Highways consultation response dated 27th June raised several issues as follows:

The applicants have now provided SPACE Architecture and Design Limited drawing 23.001(2-)003 rev B showing parking and turning for the largest vehicle anticipated to regularly access the site and have confirmed that San Pedro Properties Ltd will arrange for a private company to collect refuse from the site and that this will also be done using a 3.5 tonne van.

Scale	Date	Drawn	Checked	Drawing Number	Revision
as noted	01.03.23	MD	md	23.001(2-3003)

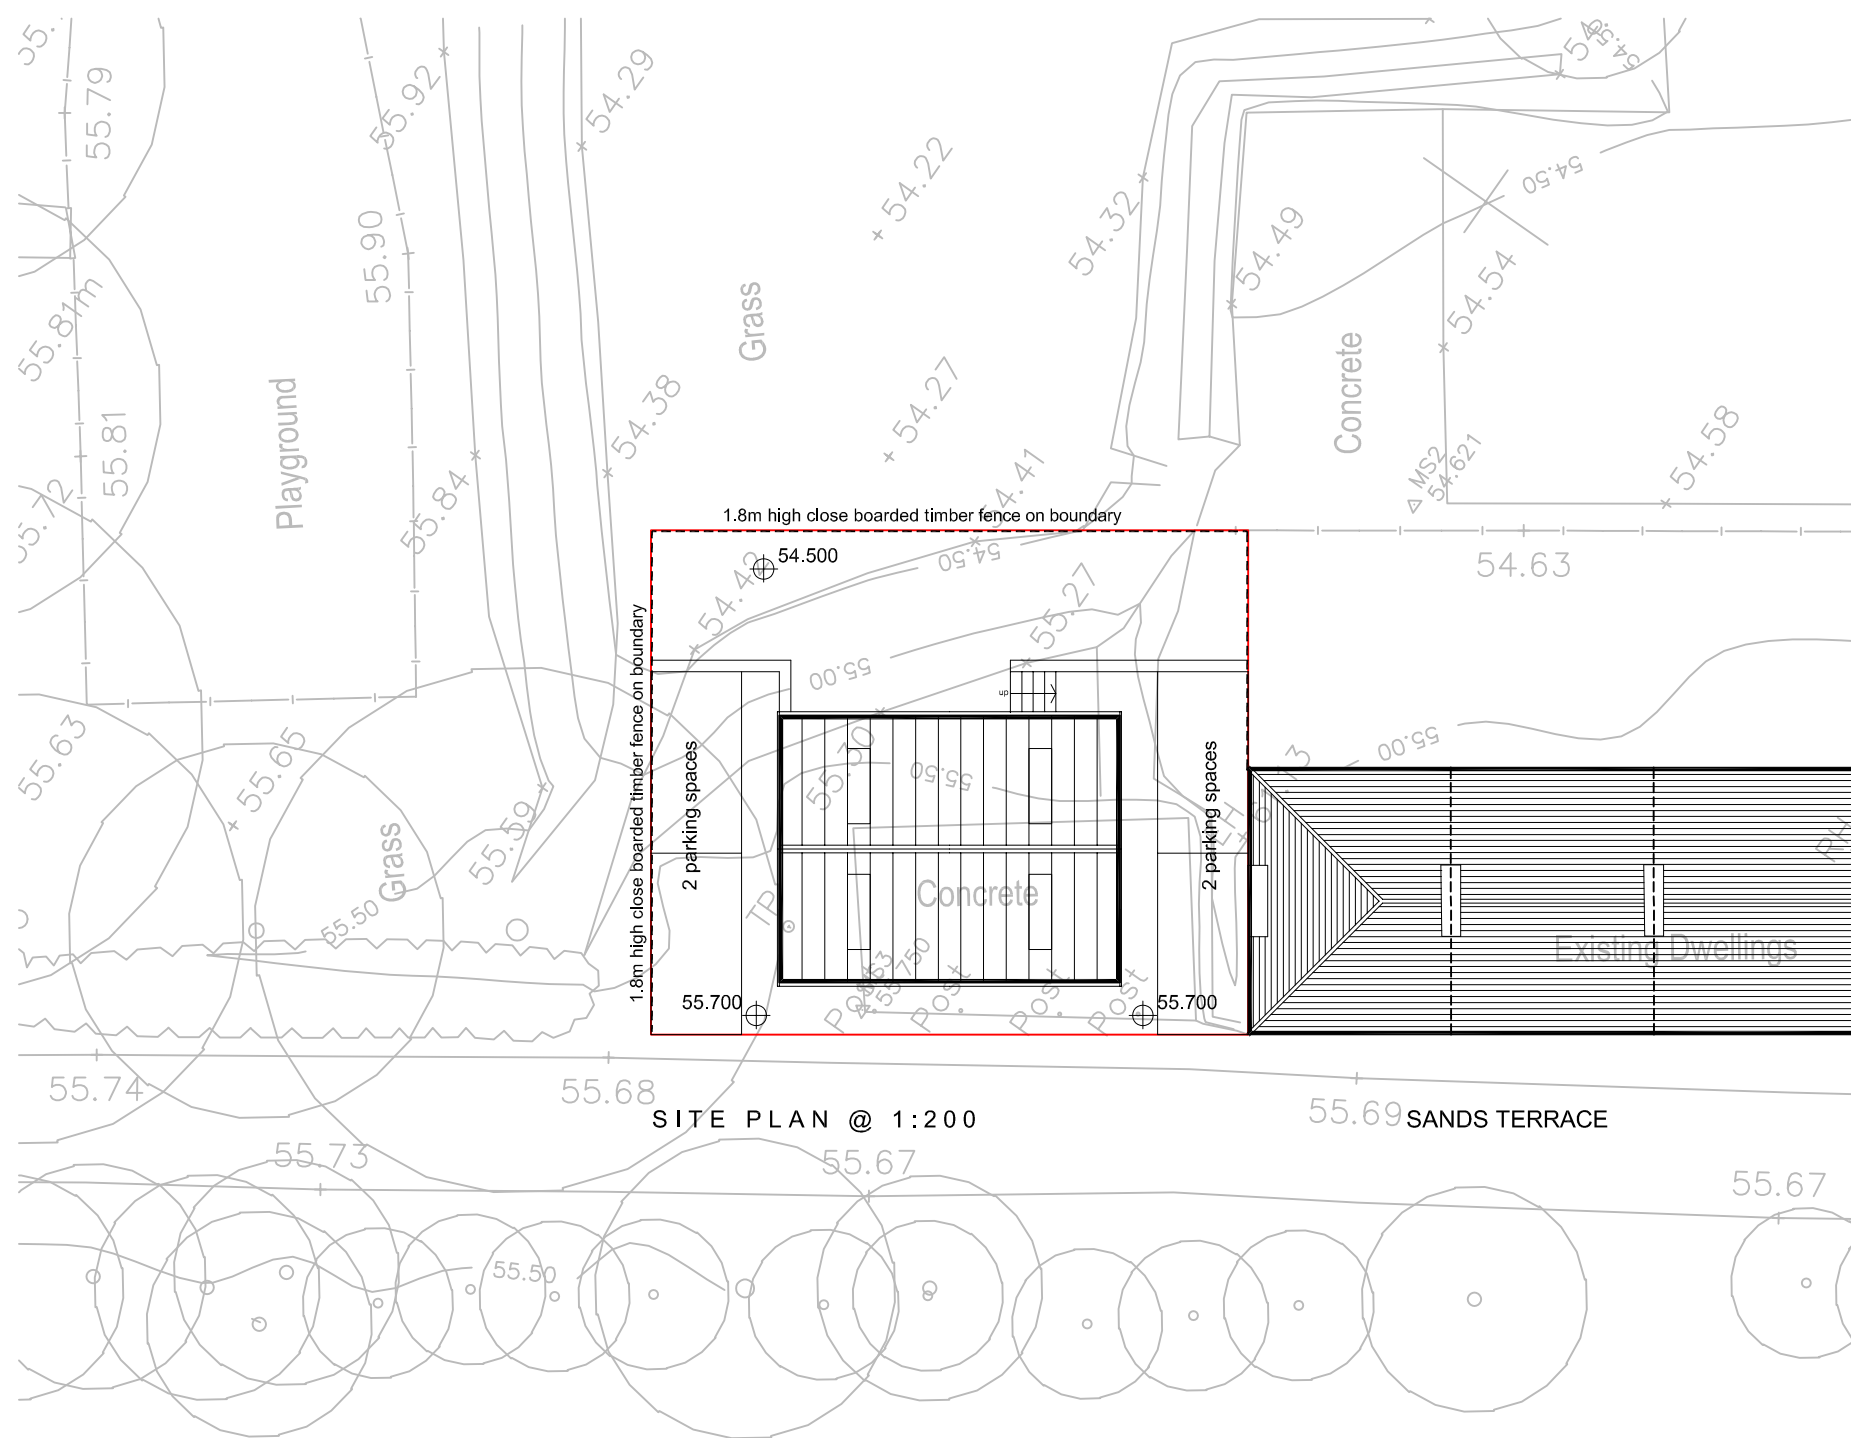
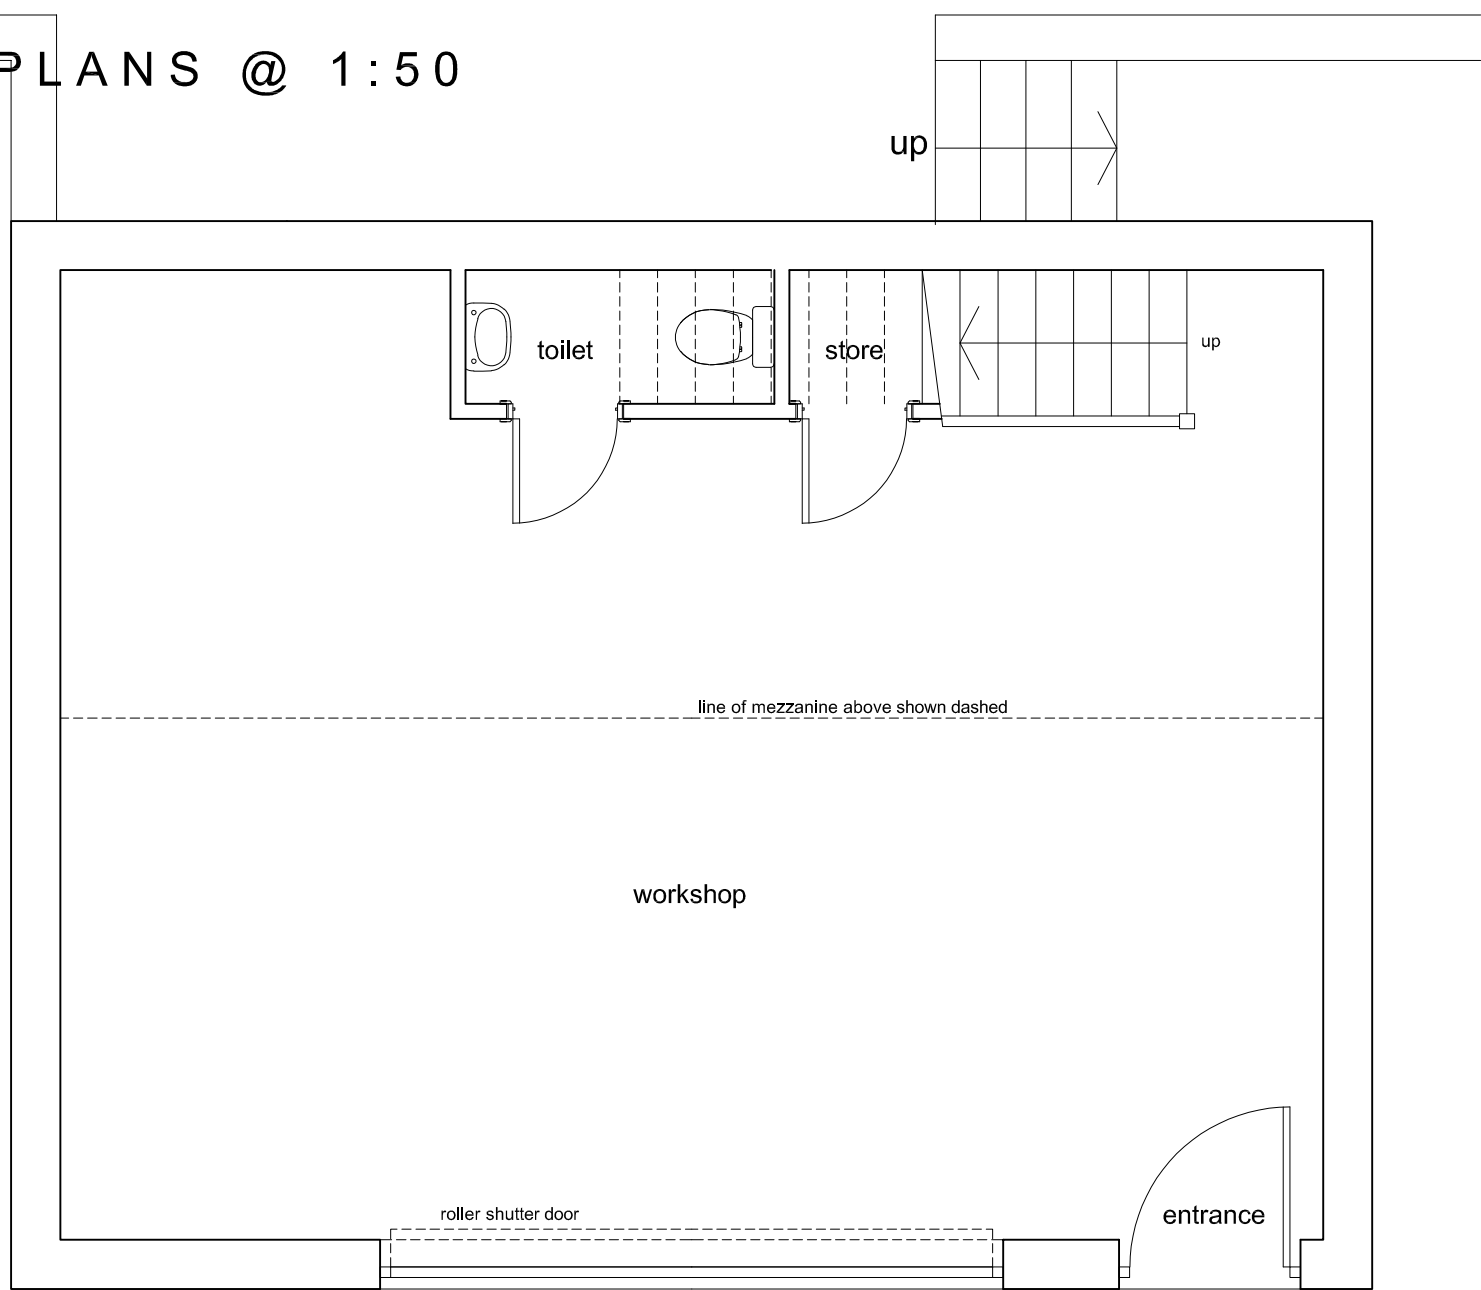
1, There are however no proposals for servicing the proposed workshop. The applicants should demonstrate by means of swept paths that the largest vehicle anticipated to visit the site can enter, exit, and turn within the site.

2, Also, no details are provided regarding the applicant's proposals for the storage and collection of wastes from the site. A refuse vehicle should not have to reverse out of the site.

These proposals are therefore considered acceptable to Highways Development Management.
